BRECKLAND DISTRICT COUNCIL

The Drovers Solar Farm (EN0110013)

Standalone Submission Following Issue Specific Hearing 3

Deadline 4 – 16th September 2026

PINS Ref. EN0110013 Drawing no.: 9485_0538

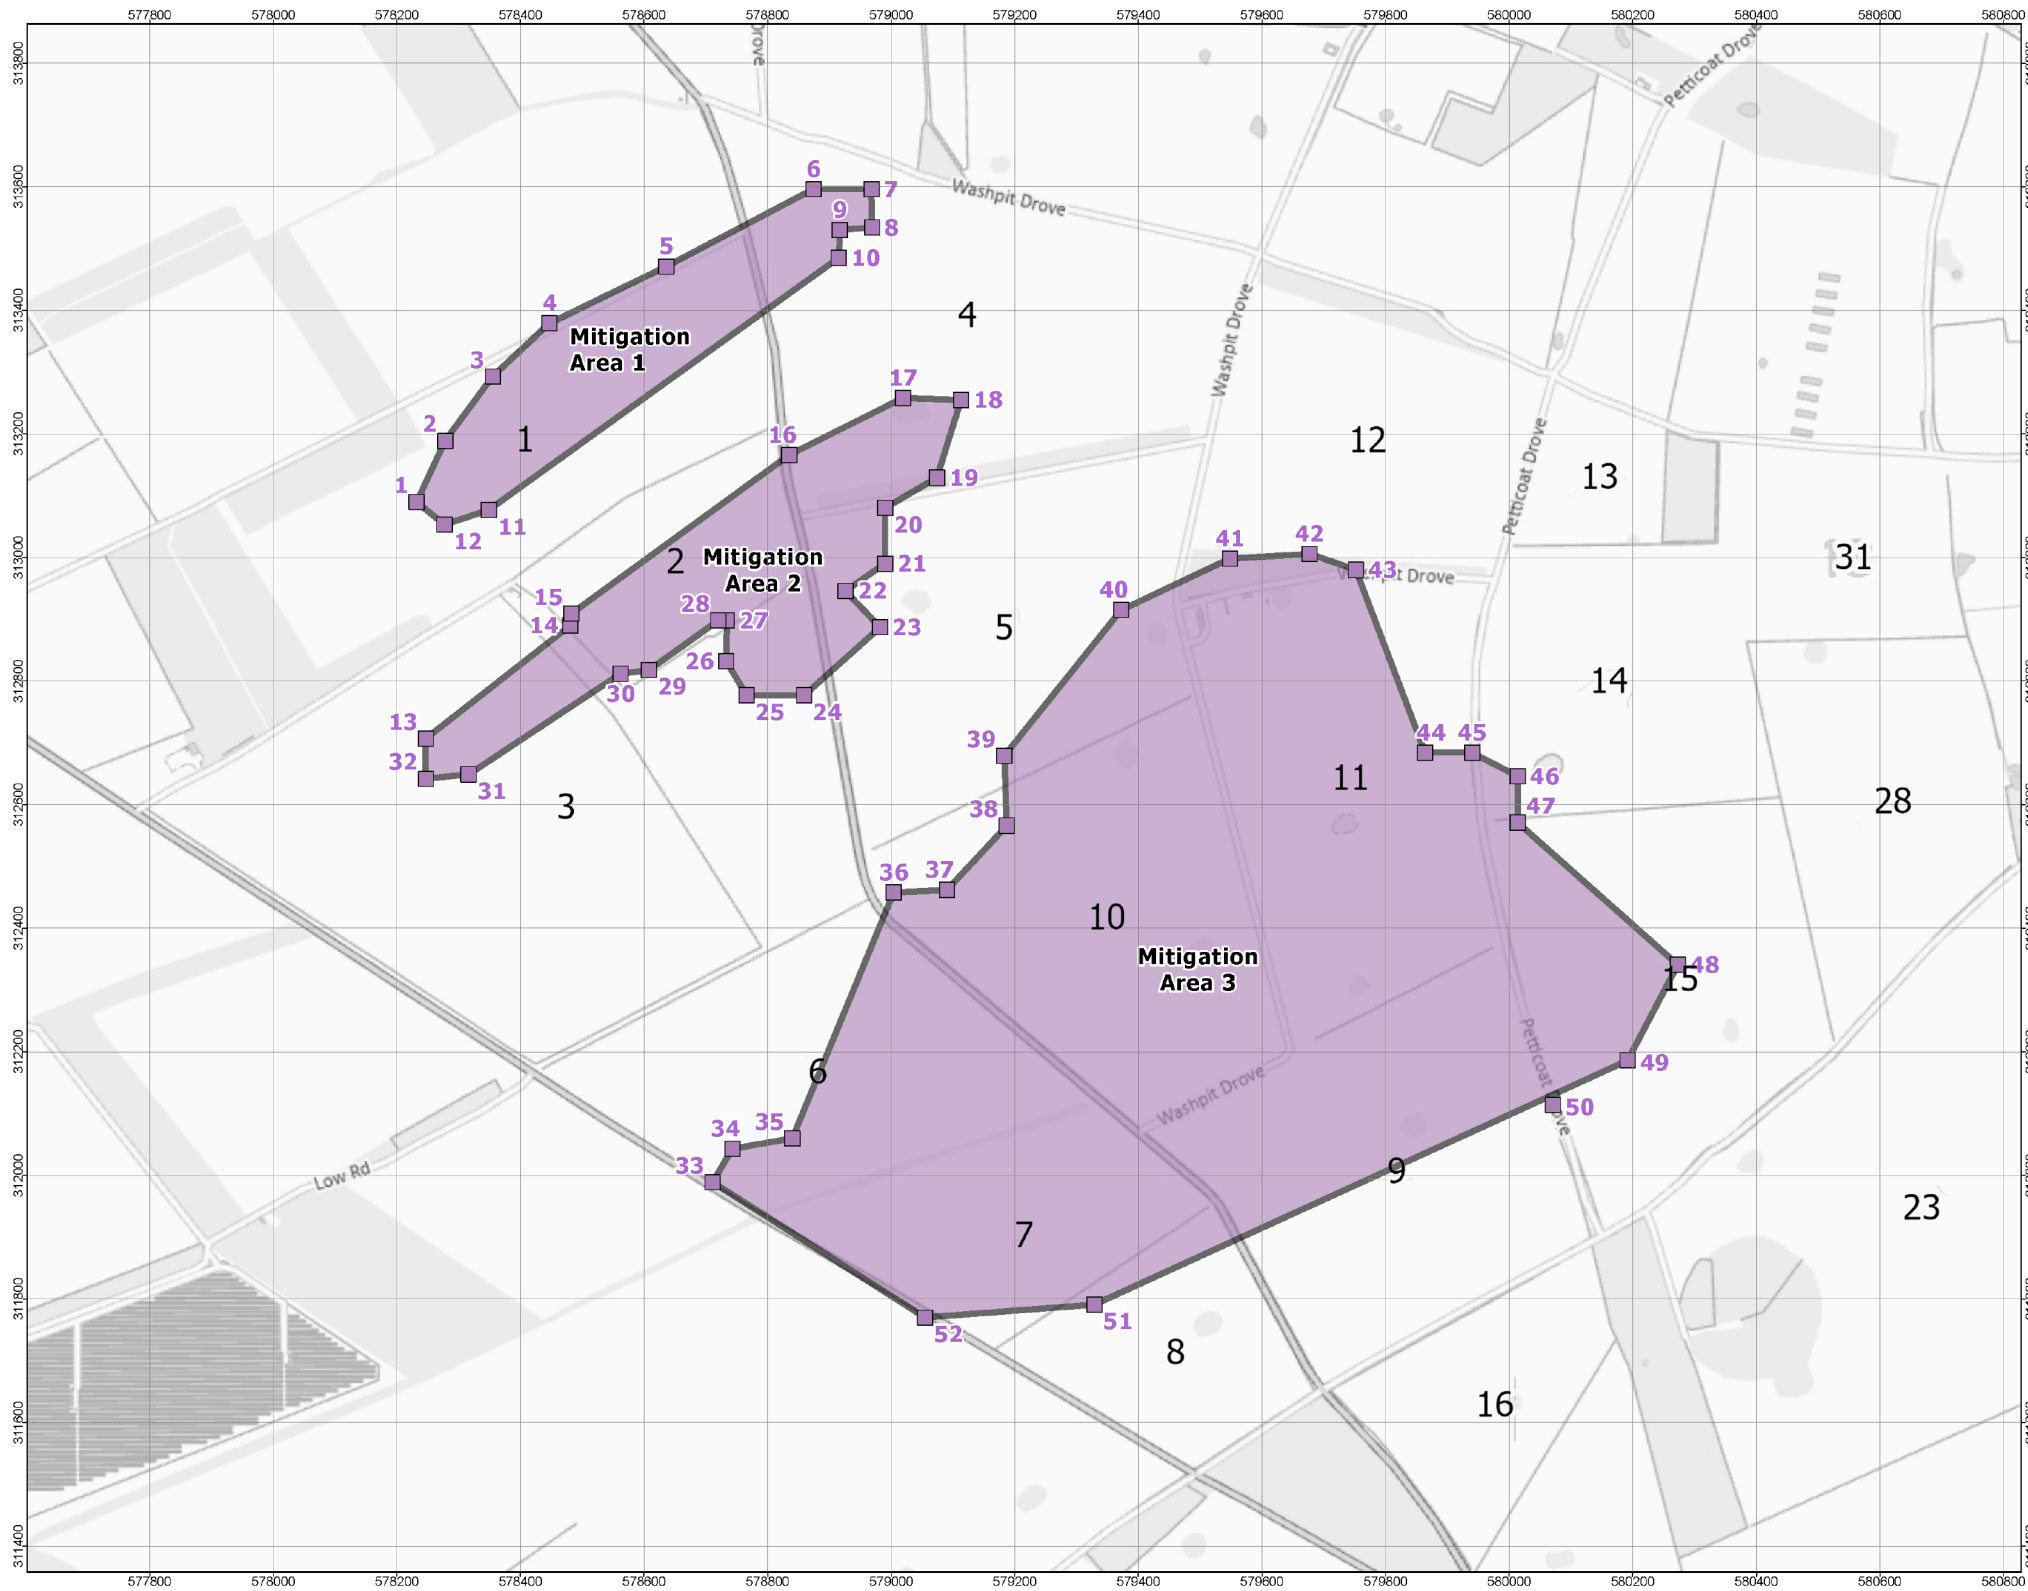
- 3.1 At ISH3, potential mitigation of effects on RAF Marham’s Precision Approach Radar was described as possibly comprising bunds, fencing or a combination of measures, potentially up to 4.5 metres in height. It was also indicated that this mitigation could affect several fields in the western part of the Order Limits. However, the final form, height, location and extent of the mitigation have not been confirmed, with the DIO unable to confirm if 4.5m would be sufficient. The plan referred to during the hearing has not yet been made available to the Council for detailed consideration.

- 3.2 The Applicant stated that should 4.5m be insufficient, the relevant solar panels would not be installed. As such, the Applicant’s position was that given any mitigation would be no higher than 4.5m, it would be within the Development Consent Order parameters in the event consent is granted. The applicant also noted that while bunds would be incongruous, they would not give rise to ‘new’ significant effects but may give rise to ‘increased’ significant effects. Breckland is not aware of any evidence that supports this conclusion.

- 3.3 The Council is concerned that this information has emerged at a very late stage in the Examination and remains insufficiently developed to enable a full and informed assessment. Depending upon its final form, the mitigation could give rise to additional or increased effects on landscape character, visual amenity, agricultural land, drainage and ground levels. It is paramount that any such effects are included within the Environmental Assessment and assessed by the Examining Authority prior to determination.

- 3.4 By way of illustration, a 4.5 metre high bund with side slopes of approximately 1:3 would have a substantial footprint of up to 30m and could require significant cut and fill works or imported material. The Norfolk County Council Lead Local Floor Authority Officer also noted that associated changes to drainage would require attenuation features; these could give rise to further adverse landscape and visual effects. The Council is therefore unable to conclude that the mitigation would be acceptable without clearer information on dimensions, alignment,

construction, materials, drainage implications, landscape treatment and removal or reinstatement arrangements.
